**Consultation Response from KC,
Highways Development Management**

2023/92504 verge at, Lindley Moor Road, Saledine Nook, Huddersfield, HD3 3XS

Date Responded: 12/09/2023.

LOCATION PLAN  
SCALE 1:1250

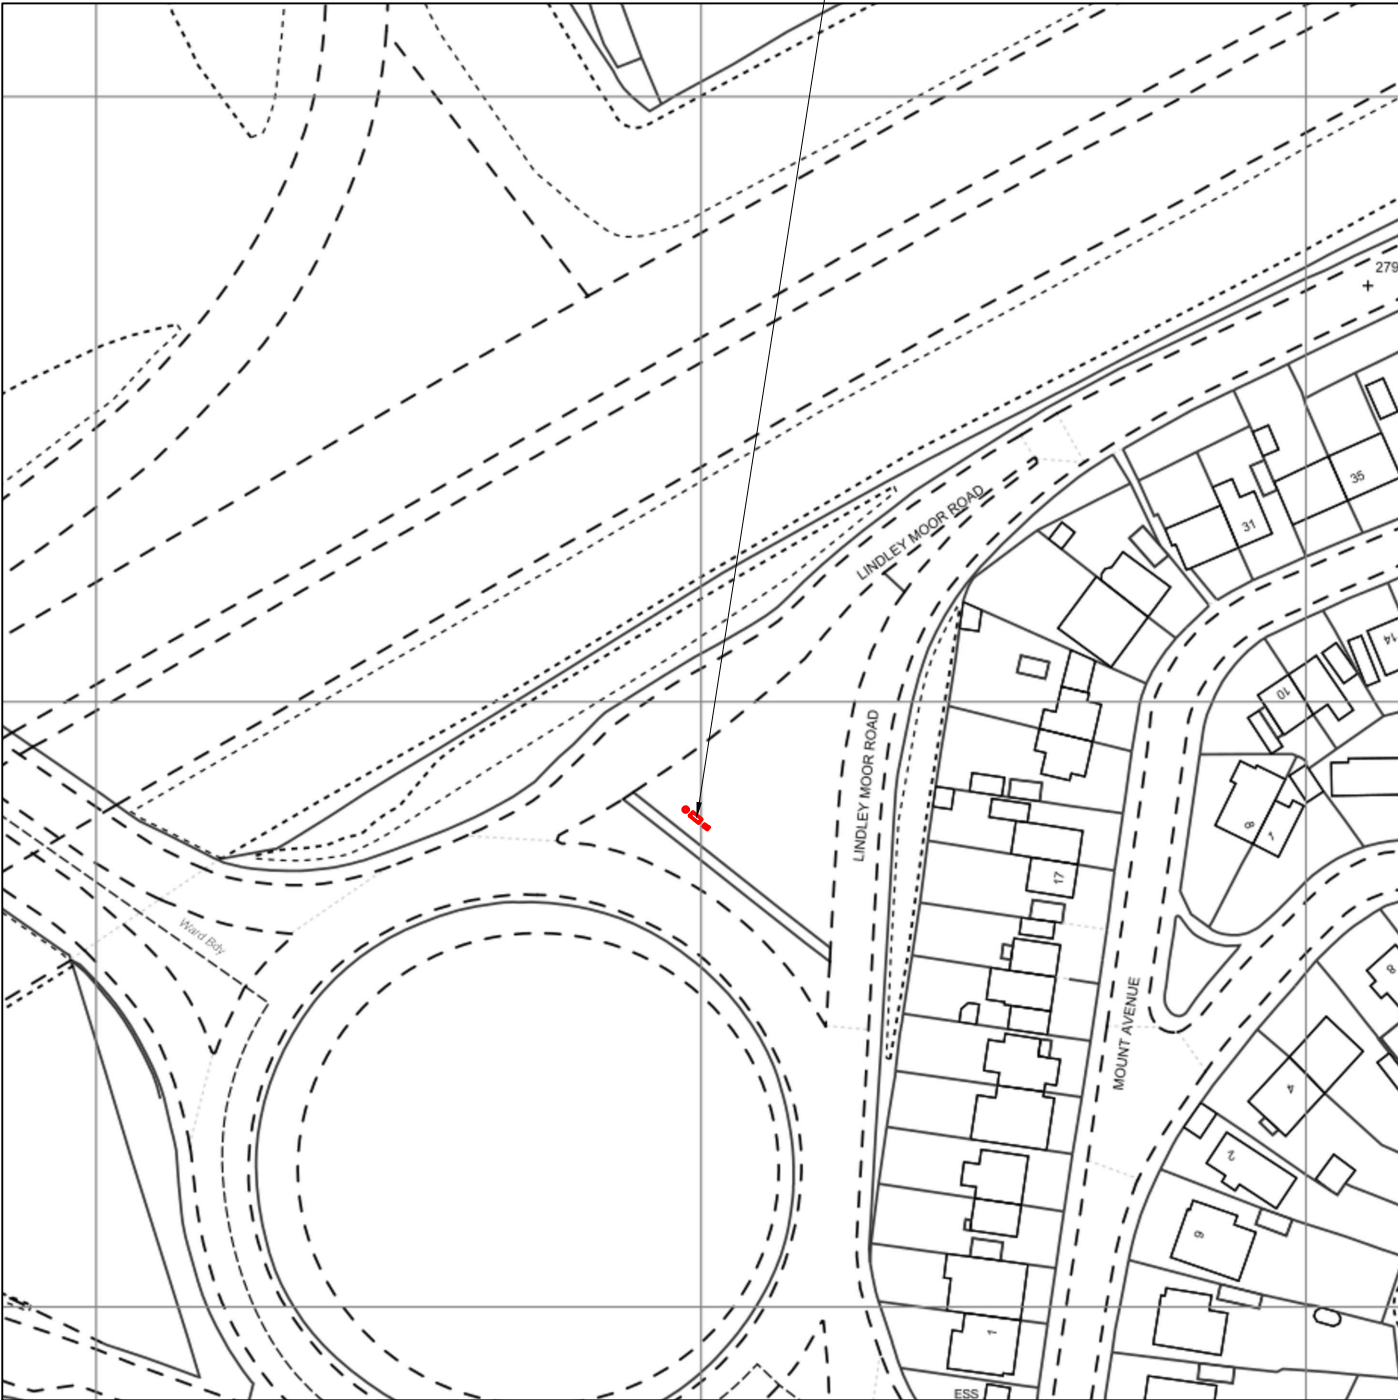
The site is located on a wide central refuge and is set back far enough to not to impact visibility splays at the adjacent roundabout junction.

The siting of a crane within the highway adjacent to this junction will cause an obstruction and require traffic management.

The presence of the adjacent roundabout junction at this location will also need to be addressed in the construction management plan

However, a condition requesting a construction management plan for the installation of the equipment and a maintenance plan for the ongoing maintenance of the equipment will be required.
